Our ref: SSI-4963
Your ref: SF2015/017648
File: OBJ14/11502-3

11/02/2022

**Pacific Highway - Woolgoolga to Ballina - Biodiversity Offset Package W2B (SSI-4963)
Biodiversity Offset Package September 2021**

Figure 4.33: Distribution of vegetation types across Site 54 (taken from Harre and Knock, 2017).

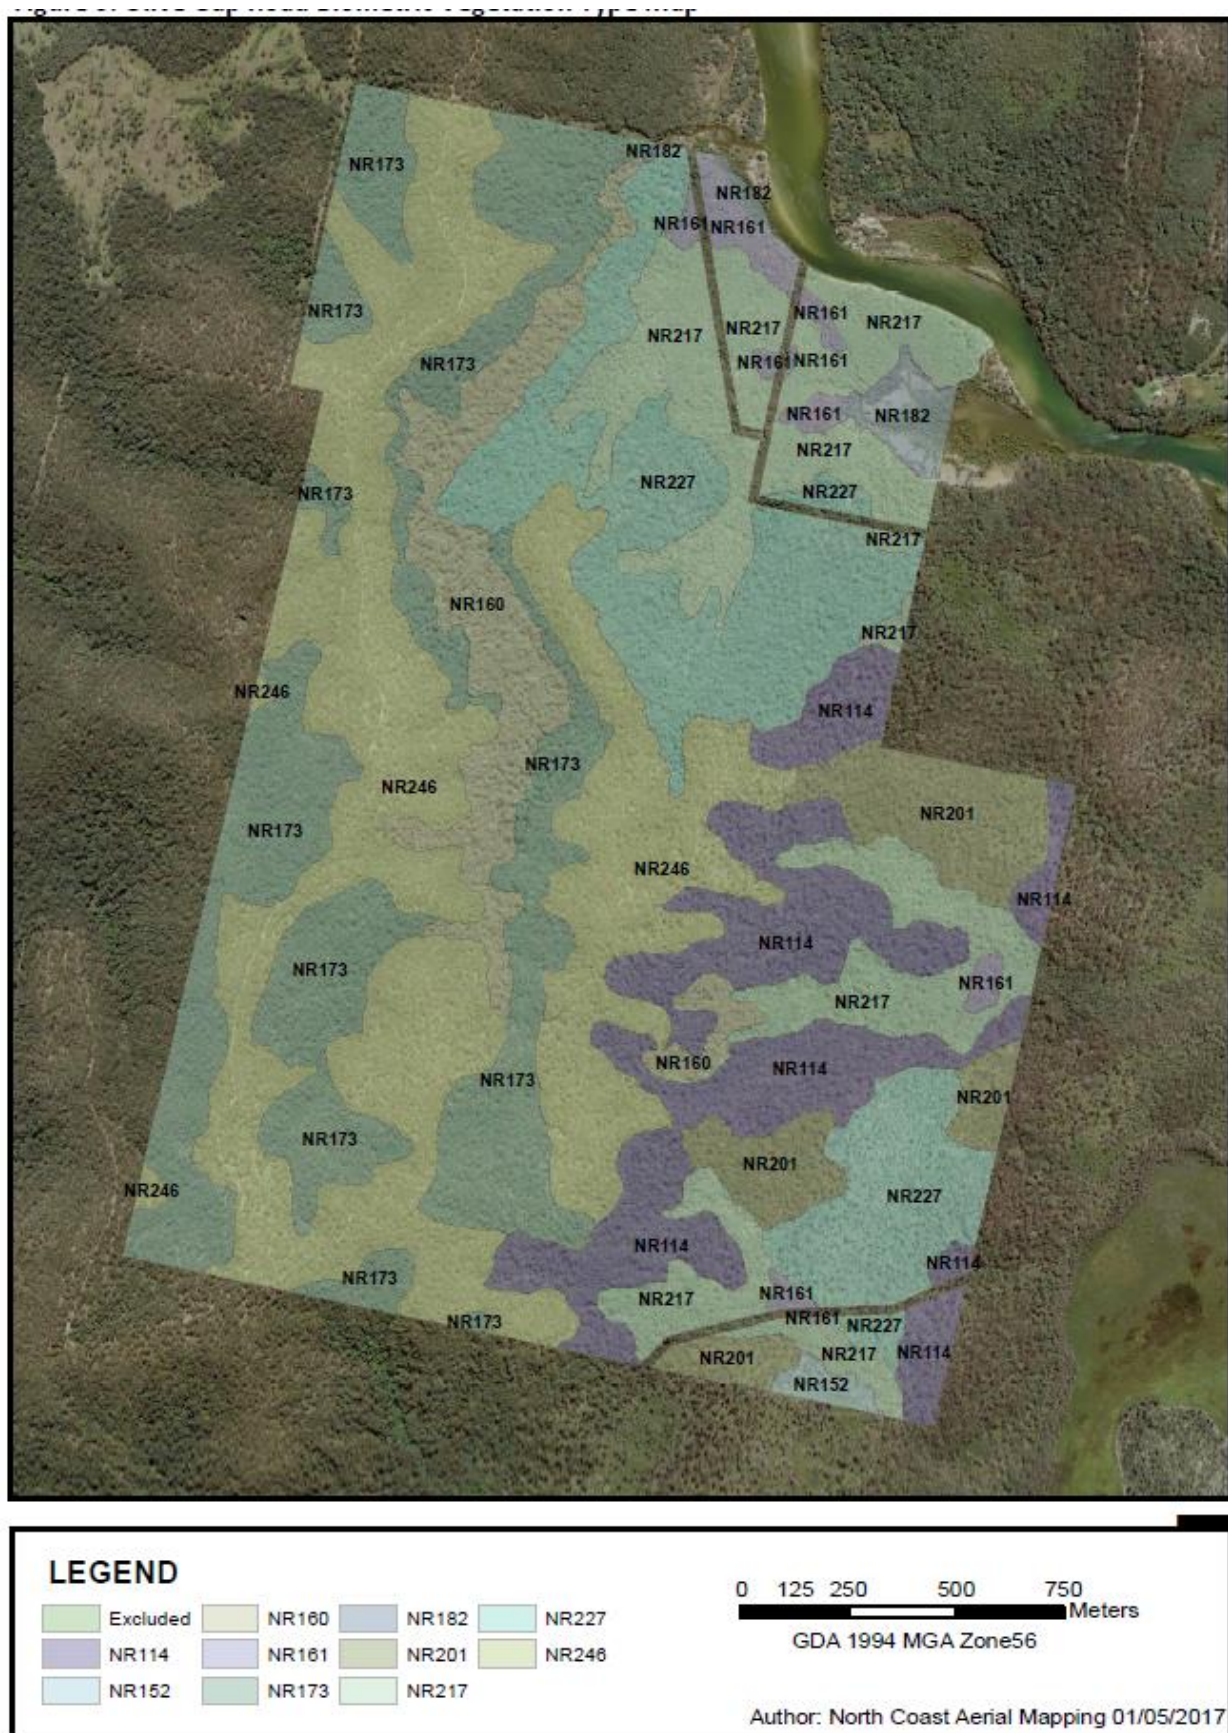
1. Providing confirmation of the offsets for saltmarsh and mangrove communities and the timing for the provision of these offsets, their location and how the site(s) will be protected in perpetuity. The views of DPI-Fisheries on the proposed offsets must be provided, and;
2. Status of the final offset property (Site 54) to be secured. Confirmation that the site has been secured must be provided to the Department.
